**Our ref:** RA/2023/146640/07-L01  
**Your ref:** 2023/93539

**(AMENDED PLANS/DOCUMENTS SUBMITTED) OUTLINE APPLICATION, INCLUDING THE CONSIDERATIONS OF ACCESS APPEARANCE, LAYOUT, AND SCALE, FOR THE ERECTION OF A SIX-STOREY BUILDING TO HOST 76 RESIDENTIAL APARTMENTS (C3 USE) AND ANCILLARY WORKS COMPRISING DEMOLITION OF VACANT BUILDING, FORMATION OF NEW ACCESS, PARKING AREAS, OPEN SPACE AND LANDSCAPING; ERECTION OF CYCLE AND BIN REFUSE STORAGE STRUCTURES**

**AT LAND ADJACENT TO LEDGARD BRIDGE MILL, BACK STATION ROAD, MIRFIELD, KIRKLEES, WEST YORKSHIRE WF14 8NZ**

### **Environment Agency position – Storm Ciara**

Project	Proposed residential scheme at Ledgard Bridge, Mirfield
Client	Binks Executive Homes Ltd, Cawthorne, Barnsley S75 4EJ
Dwg Title	(17001)10_Elevations
Scale	1:200 @ A1
Date	Jan 22

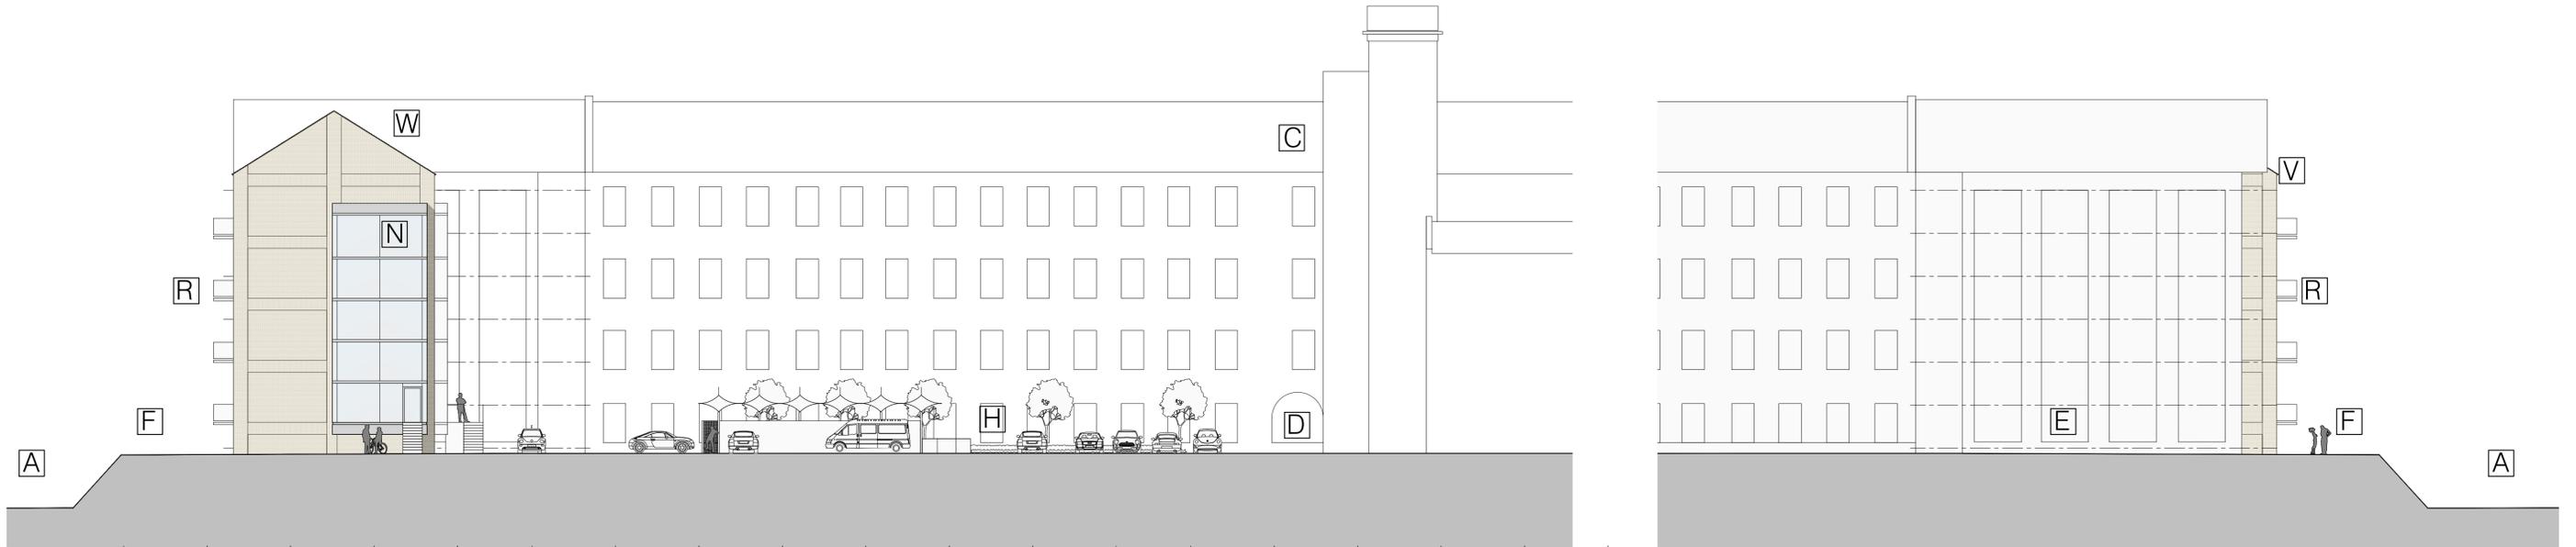
This model indicates that the 1% AEP plus 30% climate change flood event flood level is 45.38mAOD. The modelling has considered the new building as well as the walkway and has demonstrated that, even with the voids blocked, there is no increase in flood risk to others.

The proposed finished floor levels of 45.68mAOD are 300mm above the 1% AEP plus 30% climate change flood event flood level, which is considered appropriate in line with our published guidance and meets the requirement of an FRA as set out in the NPPF. We note that the FRA also indicates that the FFLs might be 46.78mAOD, this would also be acceptable in line with our proposed conditions.

- Finished floor levels shall be no lower than 45.68 metres Above Ordnance Datum (AOD)
- The proposed buildings shall be built on voids. The soffit of the void should be set to a minimum elevation of 45.68mAOD
- An elevated walkway shall be constructed from the proposed building to the bridge abutment.
